SYDNEY METRO MARTIN PLACE STATION PRECINCT – CONDITION B13 AND B14 (THROUGH-SITE LINK)

Macquarie Corporate Holdings Pty Ltd (Macquarie), is seeking to satisfy its requirements under consent condition B13 and B14 of SSD9270 in relation to the Through-Site Link for the Martin Place Station Precinct.

Public Art Location plan

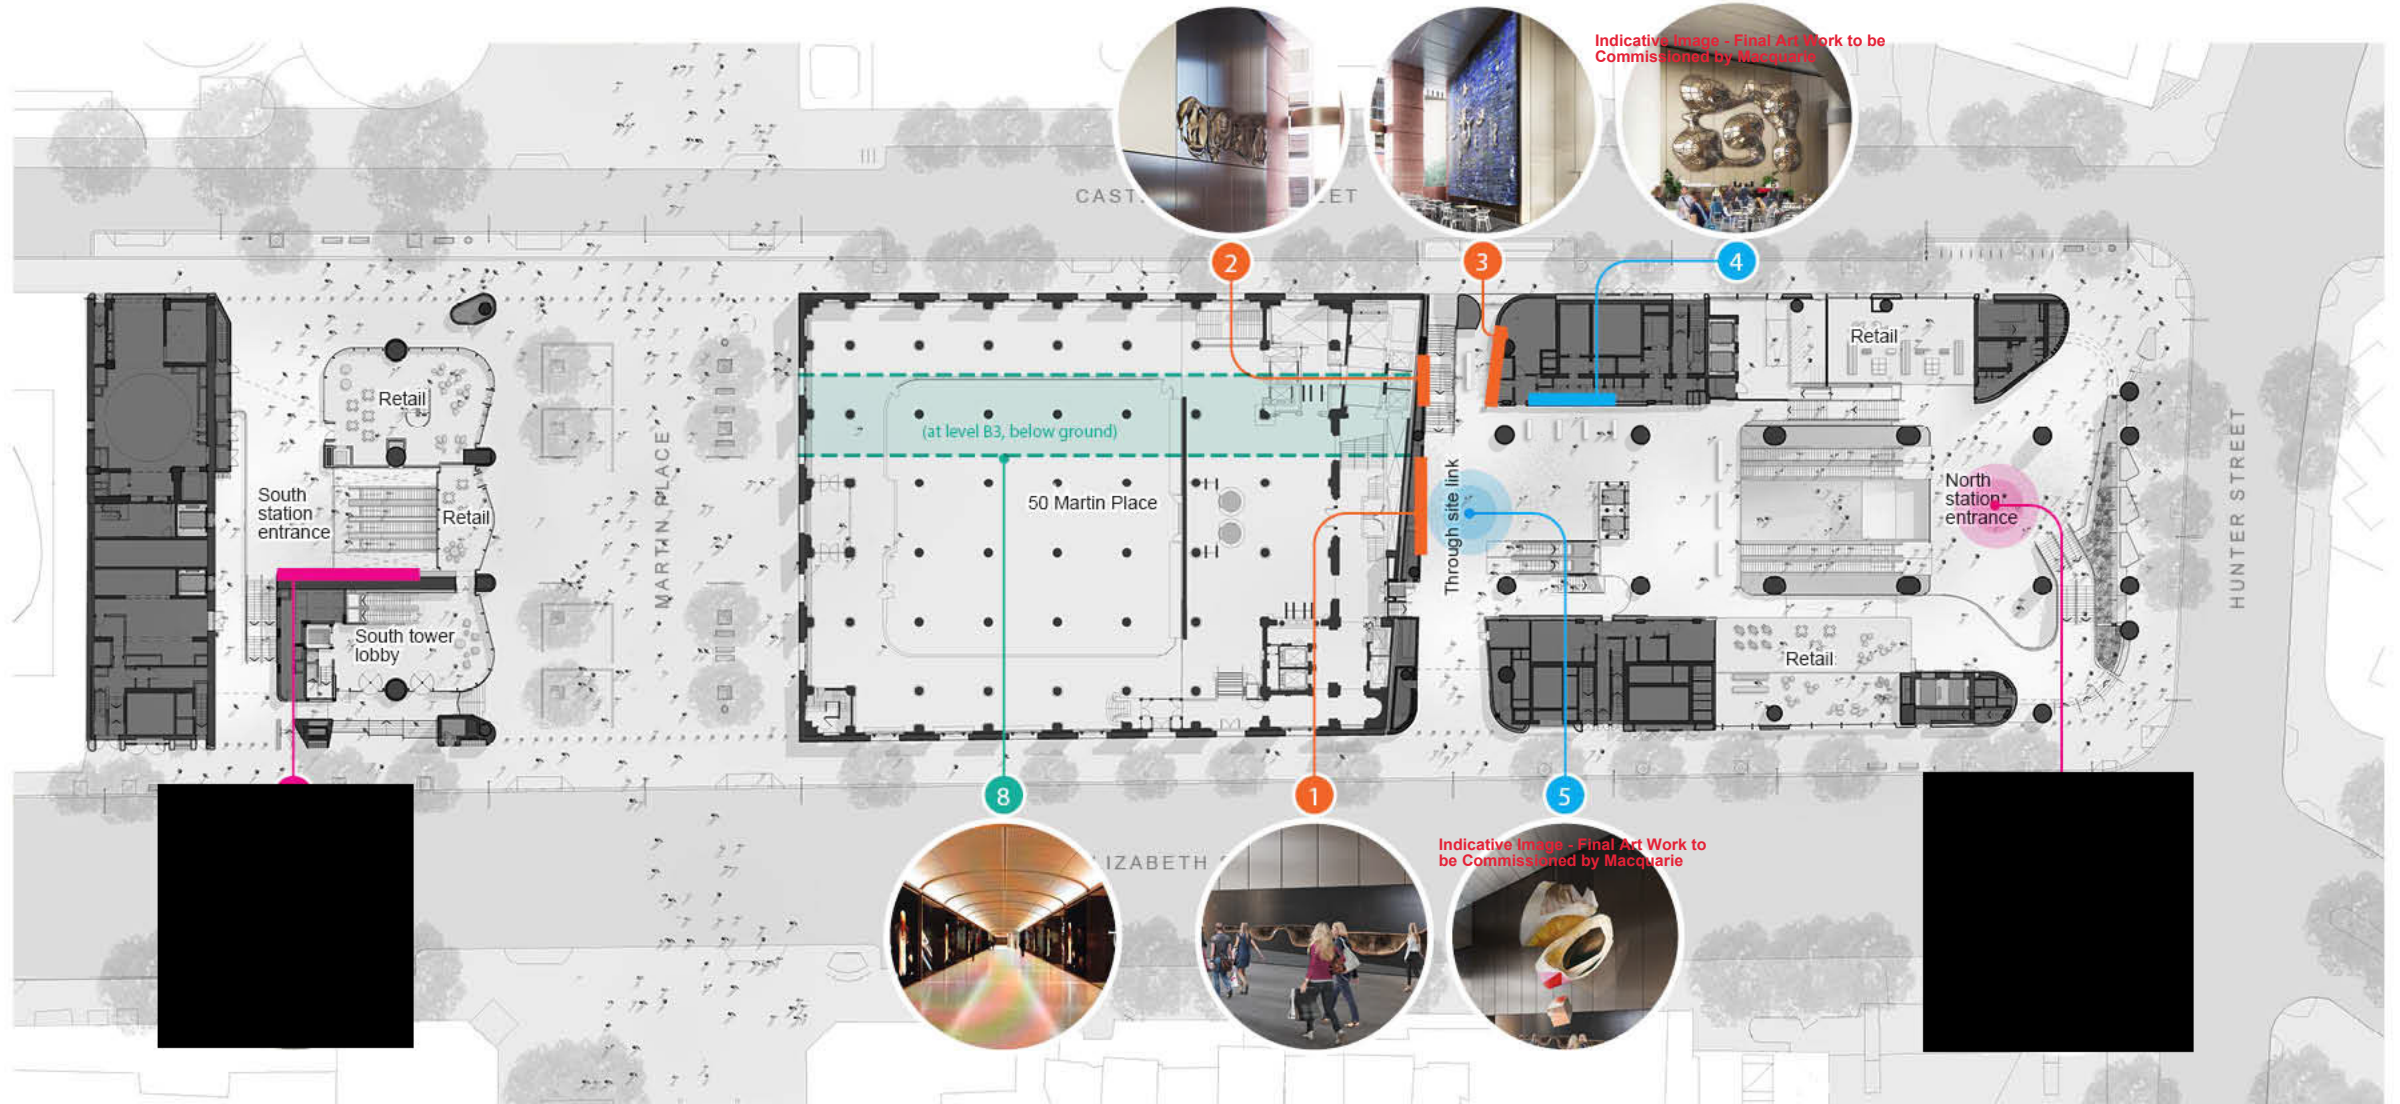
Item	DRP Advice (Session #14)	Applicant’s response
a) Public Art	<ul style="list-style-type: none"> • <i>Precise positioning of the Moebius sculpture suspended above the north station entry requires re-examination to ensure unimpeded sightlines from the eye level from all angles</i> • <i>Opportunities for the public to access information about artworks and gain further understanding through physical and digital means should be incorporated</i> 	<p>Location of the Moebius was addressed in Session 16. Height of the sculpture will be mounted approximately 5.8m from the finish floor level.</p> <p>Consideration will be given to the production of printed brochures, digital interpretation using QR codes and interpretive plaque to address public access to information.</p>

Infrastructure to support public activation Plan

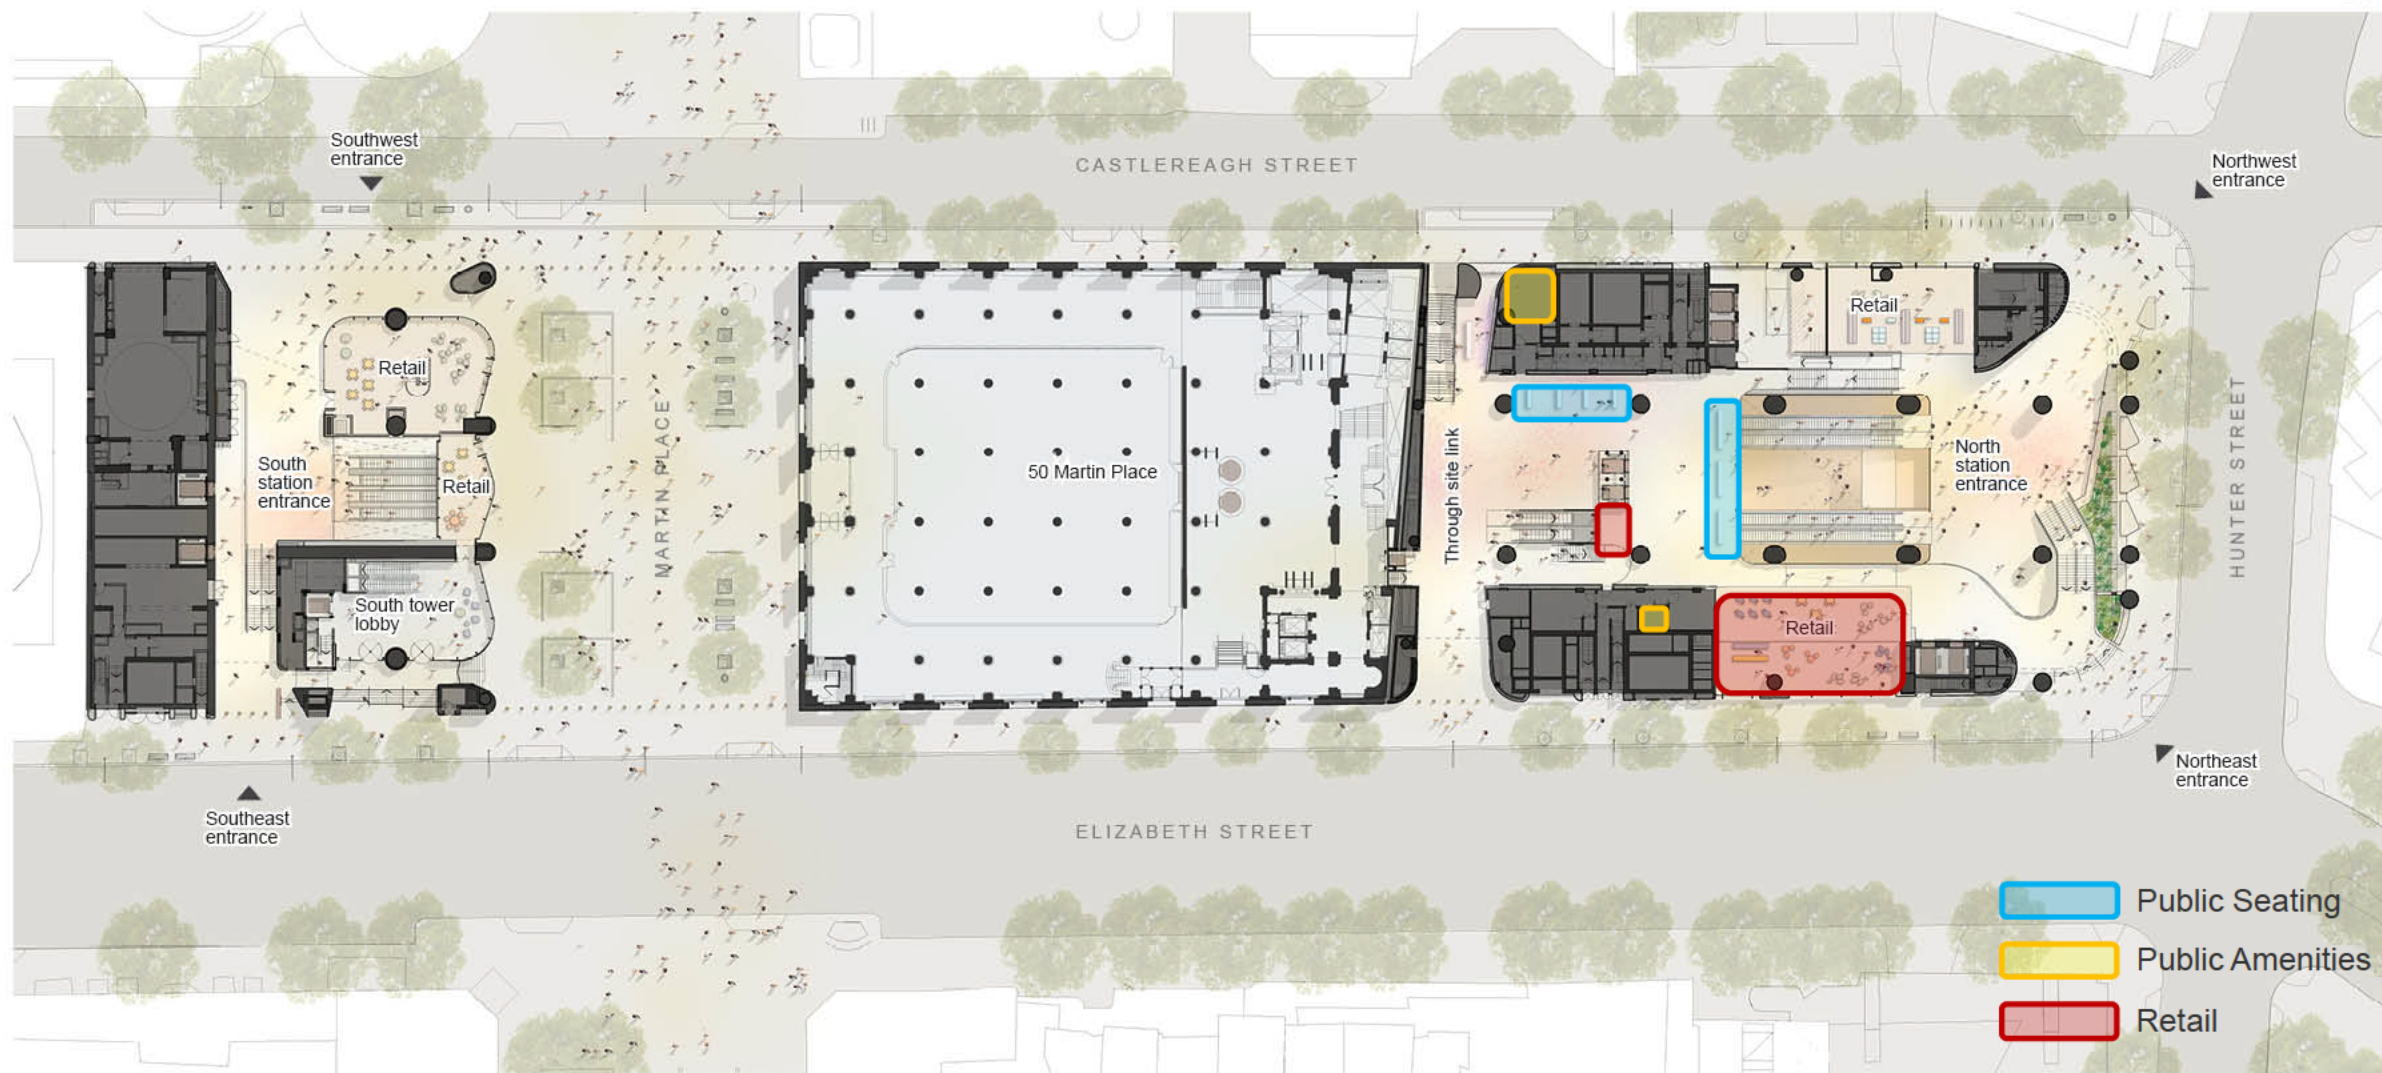
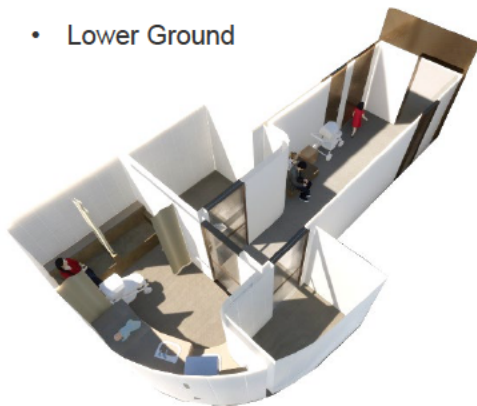
<p>b) Infrastructure to support public activation, including retail premises</p>	<ul style="list-style-type: none"> • <i>Confirmation is sought on how the number of public WCs proposed has been calculated. Provision of amenities must be sufficient to avoid queues spilling into adjacent public spaces and circulation zones</i> • <i>Design of signage, integration with the architecture and ease of wayfinding for members of the public seeking toilet facilities requires clarification and further development. Ensure integration with broader signage strategy and materials palette</i> • <i>Details of public seating and fixtures to promote uses as described (meeting place, people watching vantage point, amphitheatre –Town Hall Steps precedent) are requested for future presentation to the DRP</i> 	<p>The applicant reconfirmed and presented the amenities throughout the precinct. Amenities provided will be beyond the NCC provisions.</p> <p>Details of the signage, wayfinding and public seating were also presented in Session 16 to the satisfaction of the DRP.</p>

Function and entry experience Plan

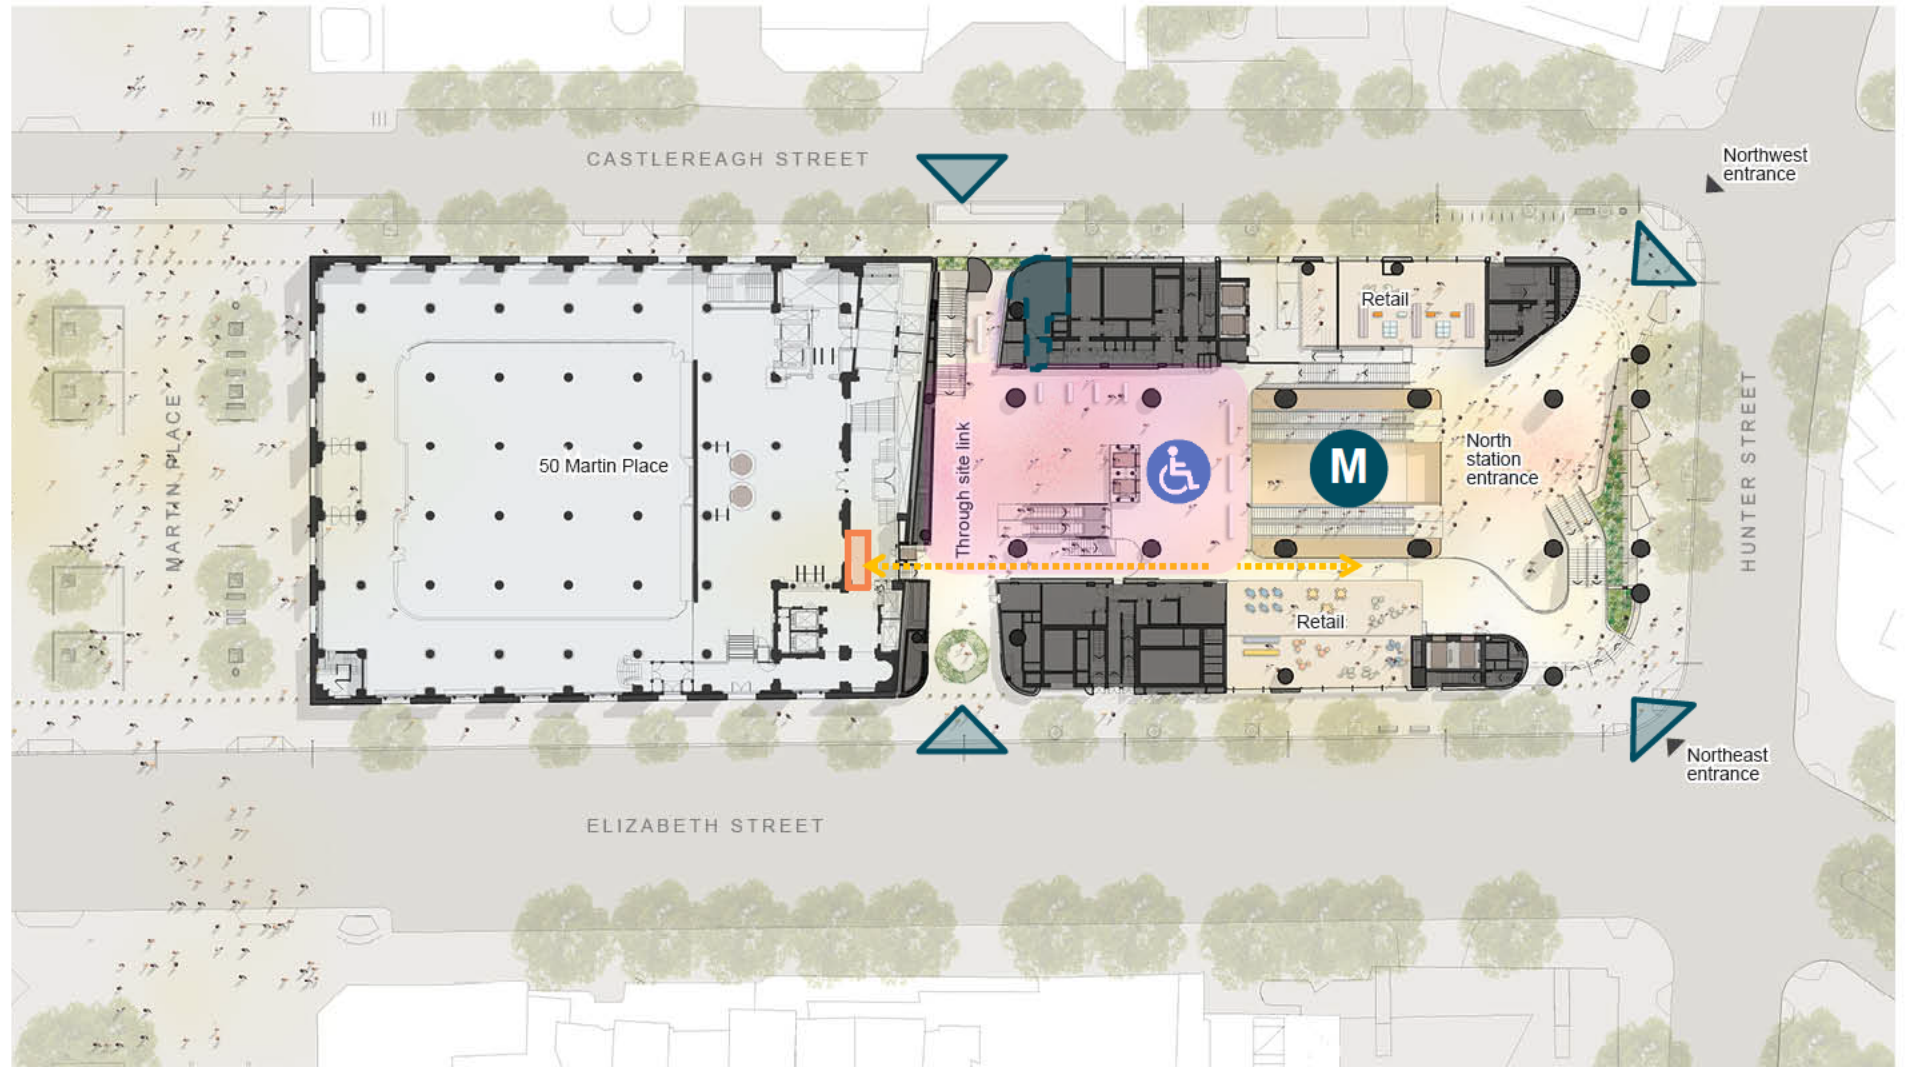
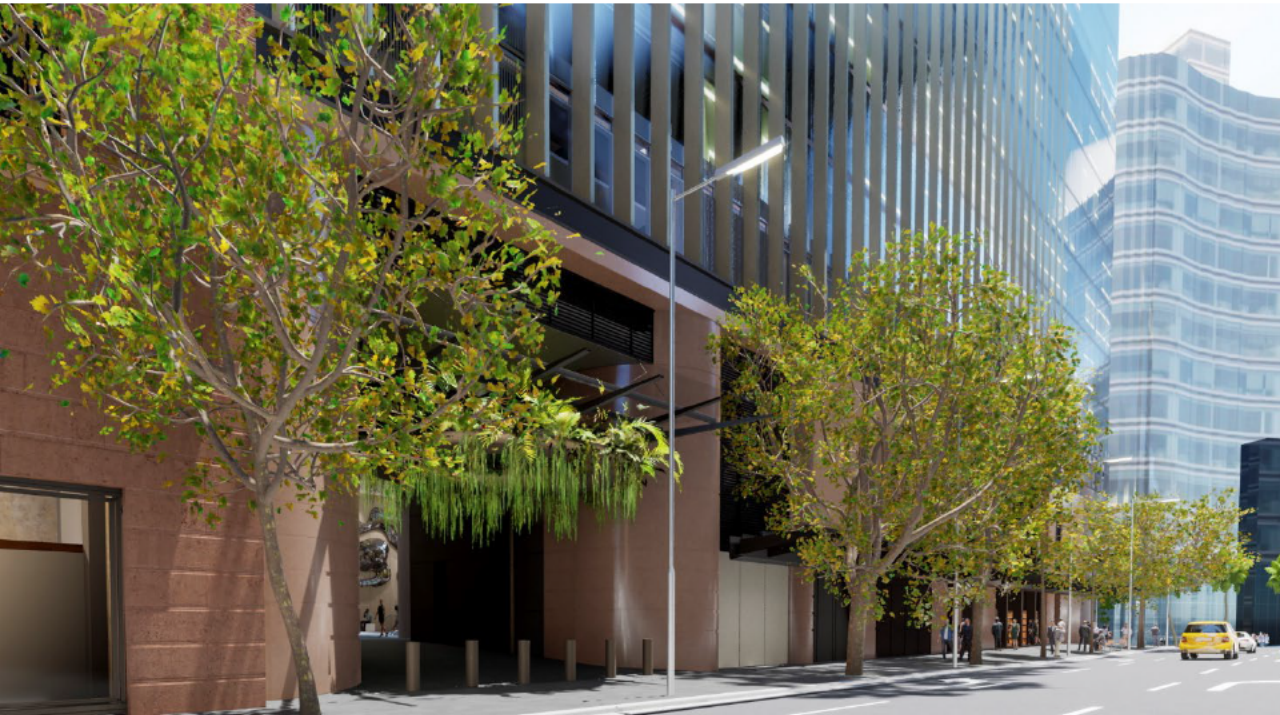
<p>c) Function and 'entry experience' requirements to provide a suitable access to a large commercial building</p>	<ul style="list-style-type: none"> • <i>The suspended landscape donut above the eastern entry requires further explanation</i> • <i>Integration of the suspended planter with the awning over, treatment of irrigation, drainage, lighting, and materials need to be clearly explained</i> • <i>The overall intention for landscaping, including entry landscaping, should be illustrated in future renders</i> 	<p>The applicant provided further details of the suspended planter including treatment of irrigation, drainage and lighting in Session 16. Render provided in Attachment B.</p>
<p>d) Safety provisions</p>	<ul style="list-style-type: none"> • <i>No comment</i> 	<p>N/A</p>
<p>e) A level of design finish suitable for a busy publicly accessible space</p>	<ul style="list-style-type: none"> • <i>No comment</i> 	<p>N/A</p>
